EPA Submission on Planning Advice Request

Thank you for the request for advice from Public Authority Consultation (PAE-30309990), requesting a review by the NSW Environment Protection Authority (EPA) of the Environmental Impact Statement (EIS) and the Proponents Response to Submissions for the proposed Sancrox Quarry Expansion Project (Application SSD-7293) at Sancrox Road, Wauchope, NSW

NSW Environment Protection Authority (EPA) Submission on Response to Submissions Report for proposed Sancrox Quarry Expansion Project (Application SSD-7293) at Sancrox Rd, Wauchope, NSW

Public Authority Consultation (PAE-330309990)
16 November 2021

Table 6.1 *Conceptual Basin Sizing*

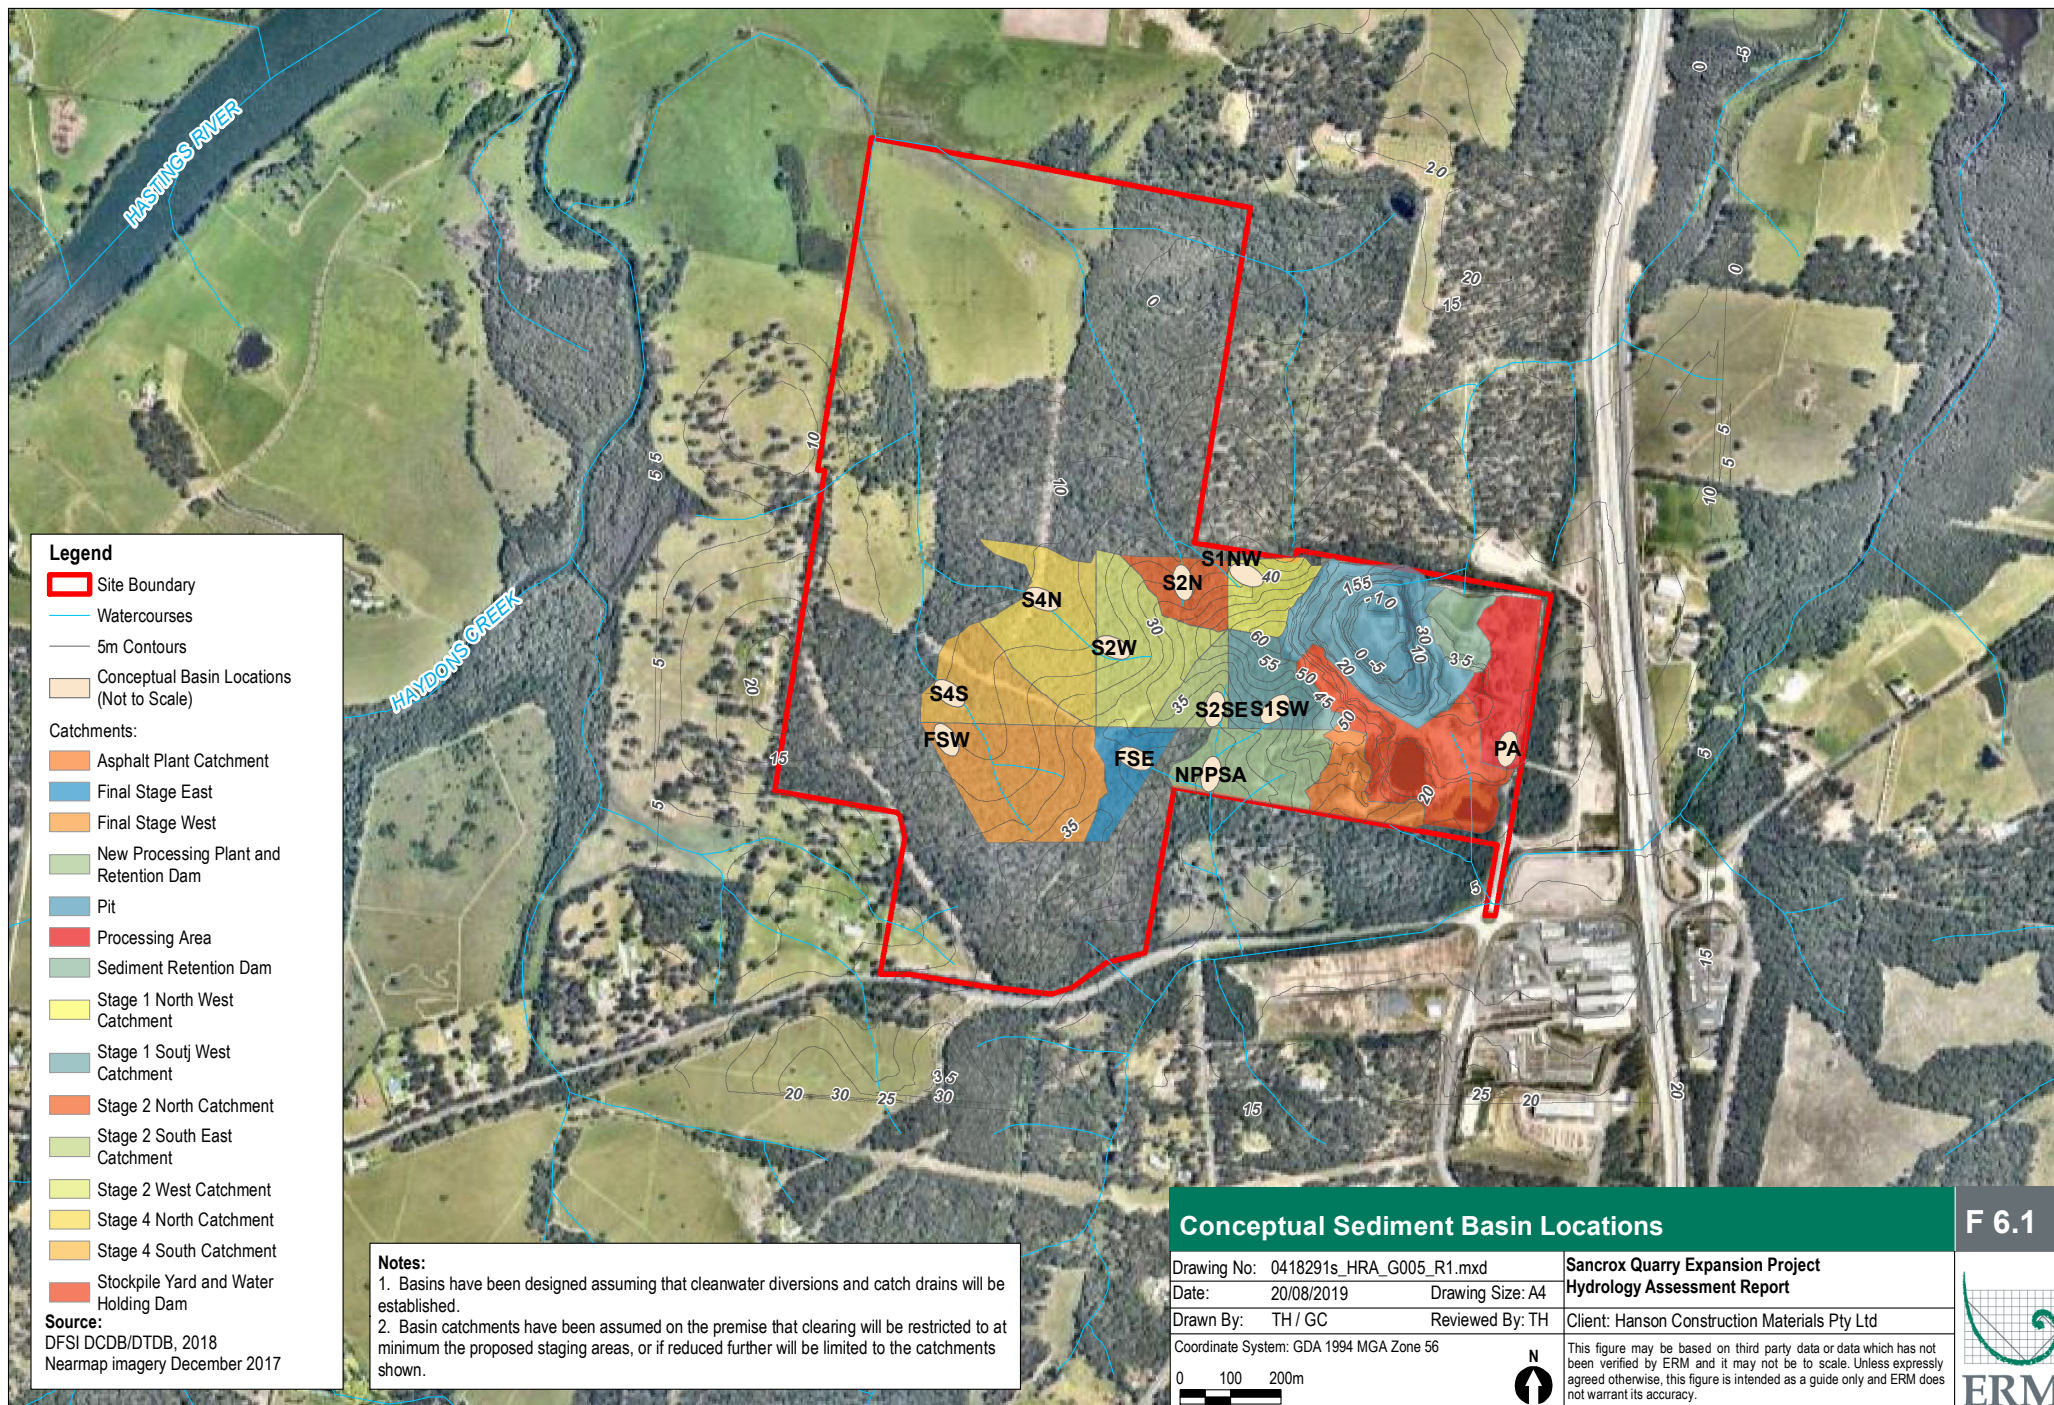
a. Water Quality - sediment basins have not been adequately sized.

The Hydrology Assessment (EIS Appendix E) states that the design storm event used in the conceptual sediment basin design was the 80th percentile, 5 day storm event of 40.1mm (as recommended for a basin with an operational lifetime of 1 – 3 years, discharging to a standard sensitivity environment, Table 6.1 of *Managing Urban Stormwater: Soils and Construction - Vol 2E, Mines and Quarries* (DECC 2008)).

The basin sizing proposed is consistent with the DECC (2008) recommendations for basins where the duration of disturbance is less than 3 years and with a 'standard' (non-sensitive) receiving waterway.

Should the project be determined by way of approval, the proposed quarry life will be 30 years. It is therefore considered acceptable to assume that the duration of disturbance from the proposed basins will exceed 3 years.

In addition, the site flows to mapped coastal wetlands protected under *State Environmental Planning Policy (Coastal Management) 2018 (Coastal Management SEPP 2018)*. Proposed basins S1NW, S2N, S4N and S4S flow to mapped Coastal Wetlands to the northwest of the site. Proposed basin NPPSA flows to a mapped Coastal Wetland to the east of the site.

The EPA notes that the Coastal Management SEPP 2018 was not considered in the Hydrology Assessment.

Recommendation: The EPA requests clarification and justification as to why the 80th percentile 5-day storm event (design storm event) was used to guide basin capacity. Consideration should be given to the proposed basin life, sensitivity of the receiving environment and the *Coastal Management SEPP 2018*.

F1.2

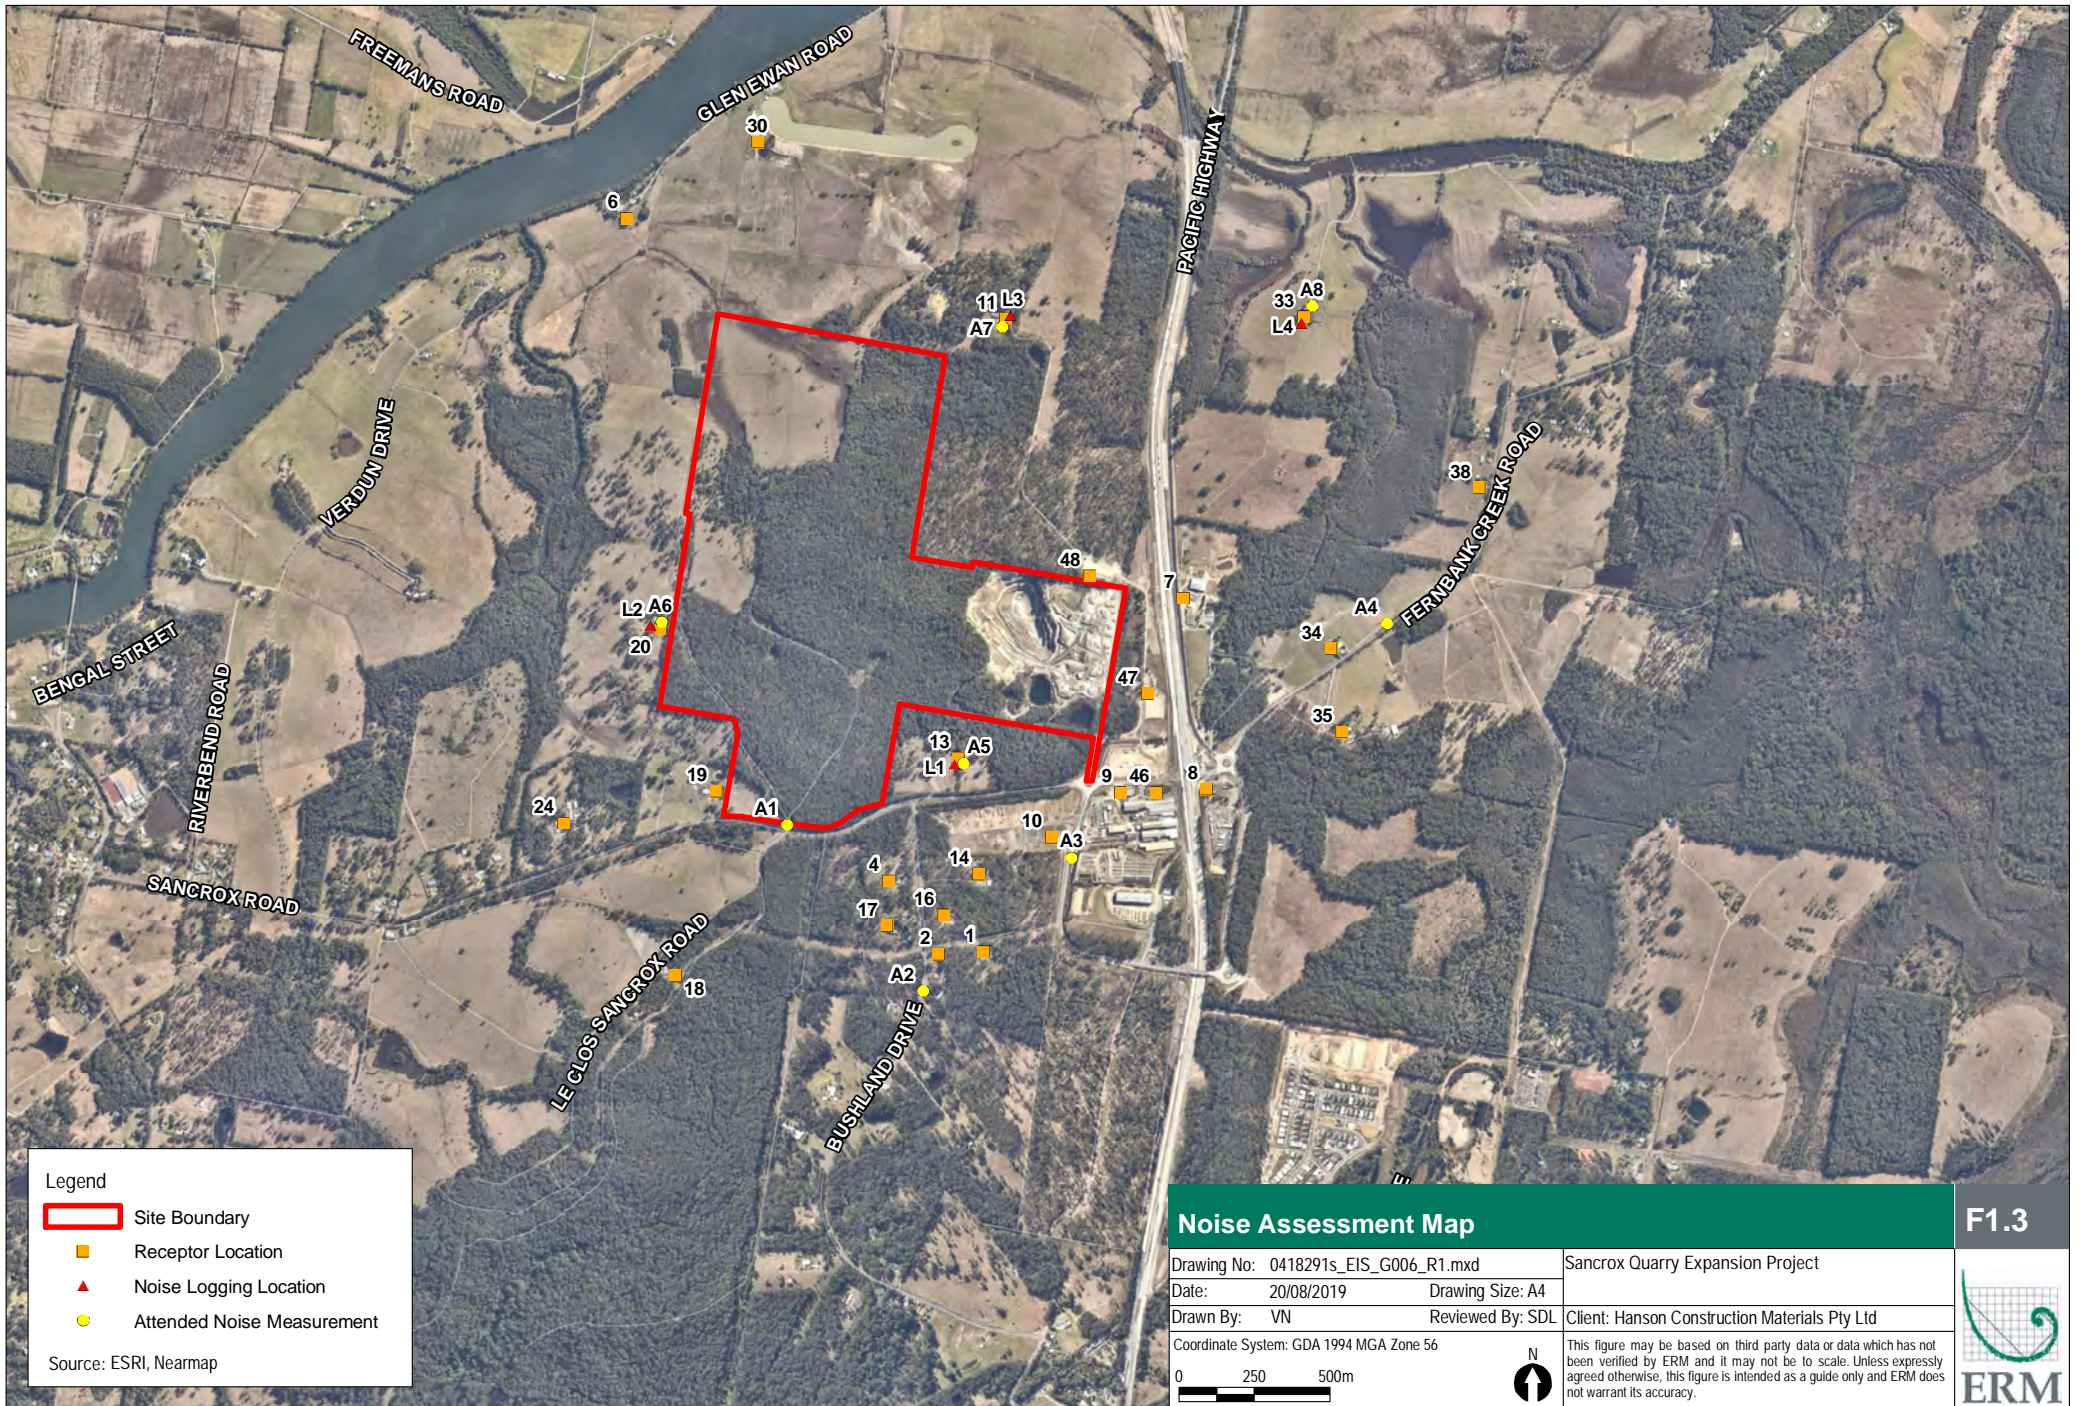
- L6.1** Noise generated at the premises must not exceed the noise limits at the times and locations in the table below. **PROPONENT TO CONFIRM ADDRESSES AND LOT DPS UPDATED NVIA FIGURES 1.2 and 1.3 do not match receiver locations and Table 3.1 appears to have errors in the coordinate system.**
